Consultation Response from KC Highways Development Management

2025/91888 Eden Banqueting, 297 Bradford Road, Batley, WF17 6HY

Part change of use and alterations to Banqueting Suite to form a mixed short-term let / café restaurant use and associated works

RECOMMENDATION: Further information and amendments required

PROPOSED SITE PLAN
1:500 @ A1

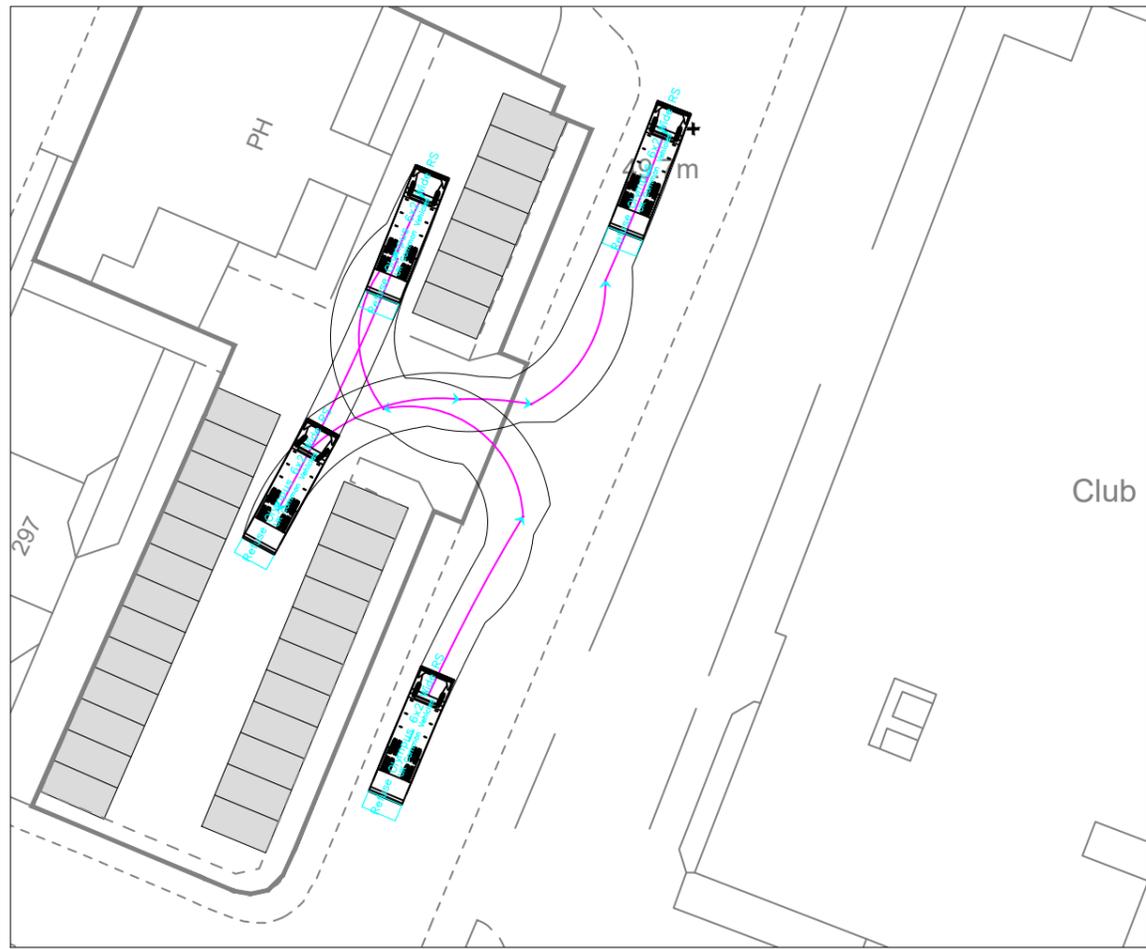
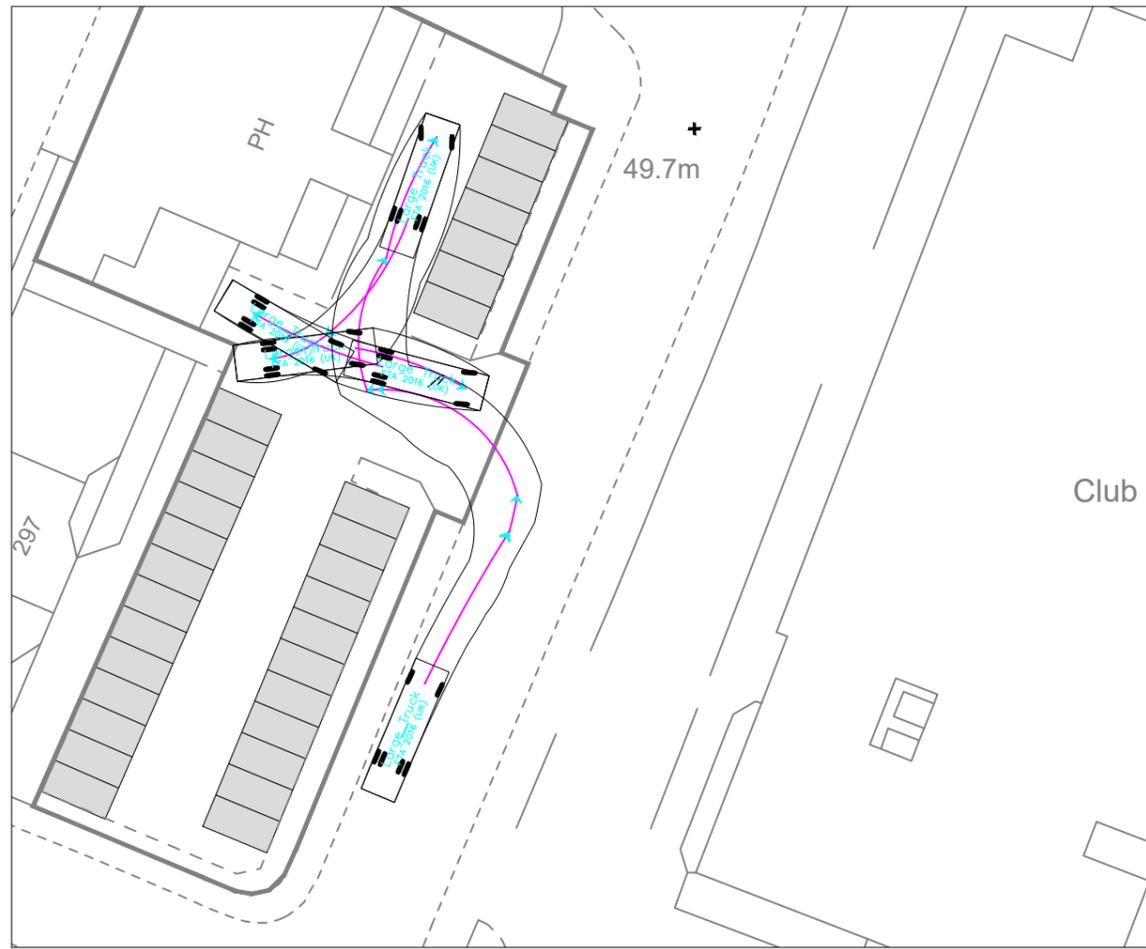
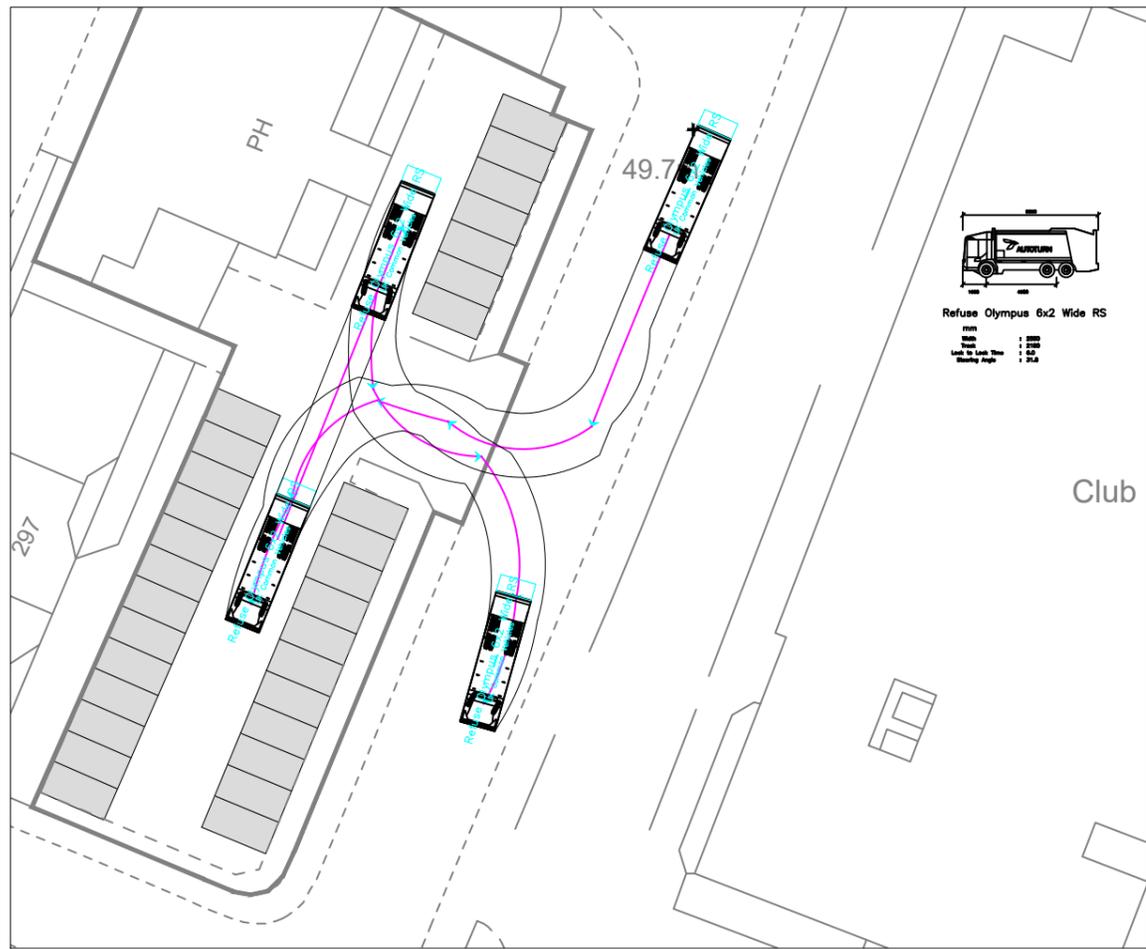
The site layout proposed appears to keep the general layout of the car park similar to the existing, however, some minor amendments are proposed to increase the number of parking spaces within the site to 32 spaces overall.

It is noted that an additional two car parking spaces are proposed in front of the Snowcold unit to replace the existing hatched markings which would increase the number of parking spaces along the western edge from 11 to 13.

The parking spaces opposite are proposed to be amended to increase the number of parking spaces from 11 to 12. It is unclear in the submitted site layout plan if the existing wall at the vehicular site access will be amended, there may be insufficient space for a vehicle to park in the car parking space closest to the vehicular access.

The area opposite the proposed hotel is proposed to be amended to fit in an additional car parking space to increase the number of parking spaces from 6 to 7, which would block access to the existing pedestrian access steps.

The proposed car parking spaces appear to have dimensions of 2.4m x 4.8m with a 6m aisle width. The LHA would recommend that spaces may need to be widened further when they are adjacent to boundary walls / railings.

No details have been provided in relation to the provision of accessible parking spaces or EV charging points which should be clarified. The submitted Car Parking And Servicing Management Plan states that there are 4 designated car share spaces, 2 drop off / taxi spaces and 2 accessible spaces, but none of these are annotated on the site plan.

At present there is a stepped access from the Bradford Road frontage and there is also a level access point from Grafton Street along the frontage of the neighbouring units, although the entrance point is narrower than 2m width, although this is not included within the site edged red at present and the route ends in front of the access for the Snowcold unit. The LHA would recommend that this footway is incorporated into the site edged red and that accessible pedestrian access from the existing footway to the property is provided as part of the proposals. The existing stepped access to the property would be blocked by the amendments to the proposed car parking layout.
